November 3, 2022

RE: Aloha Time

A plan review was received by this office concerning the construction of the above referenced facilities. Further information is needed for the review to continue:

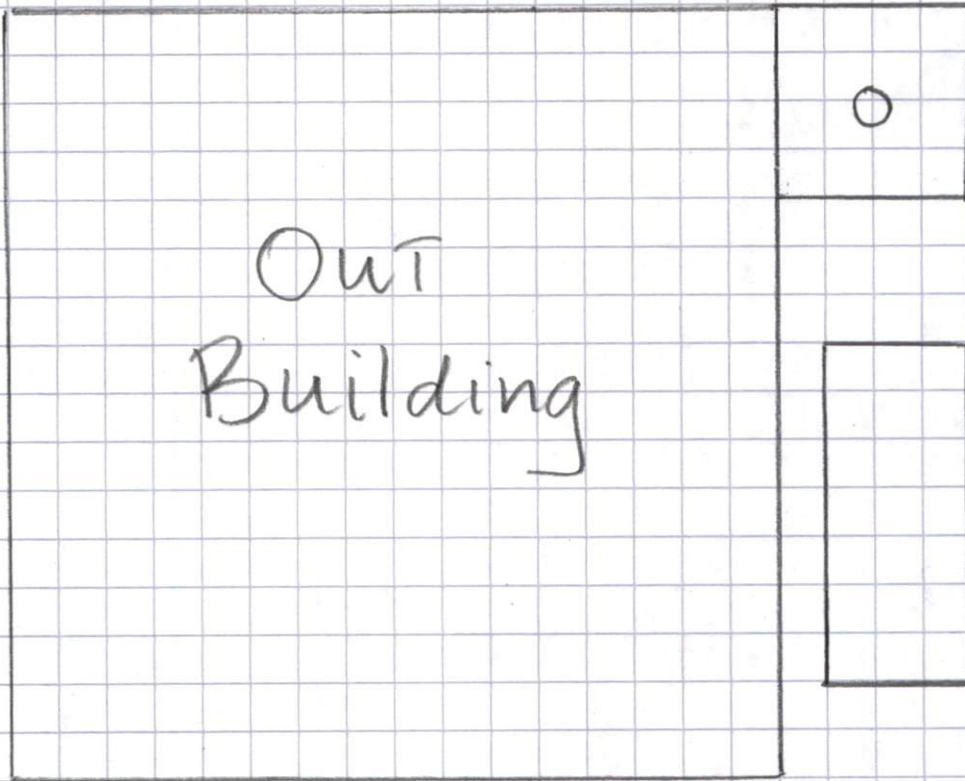
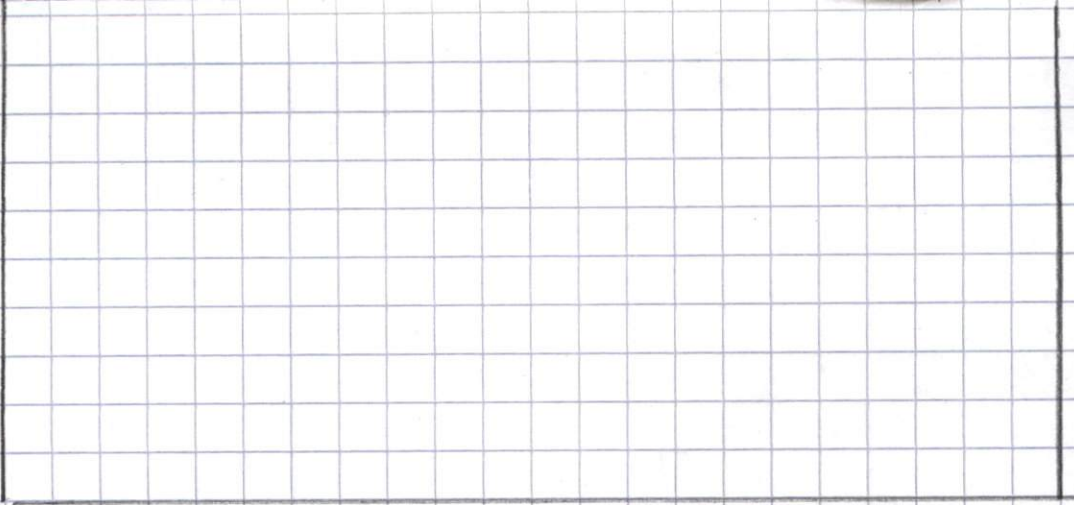
- The application indicates that time will be used as a method of control for food safety. What food items will be held for time instead of temperature?
- No specification sheet was received for the following pieces of equipment: three comp sink, one comp prep sink, shelving, catering equipment
- Where is the location of the dry good storage room?
- Where are the air drying shelves located?
- Where is the chemical storage rack located?
- The food process sheets indicate pork and chicken will not be used as leftovers however there were also cooling procedures in the same process. Will meat items be cooked and cooled?

- The proposed condiment cooler is undersized for the volume of food indicated to be stored.
- If the intention is to be majority caterer, the capacity of the current equipment appears to be undersized. There is not hot holding cabinet for bulk foods.
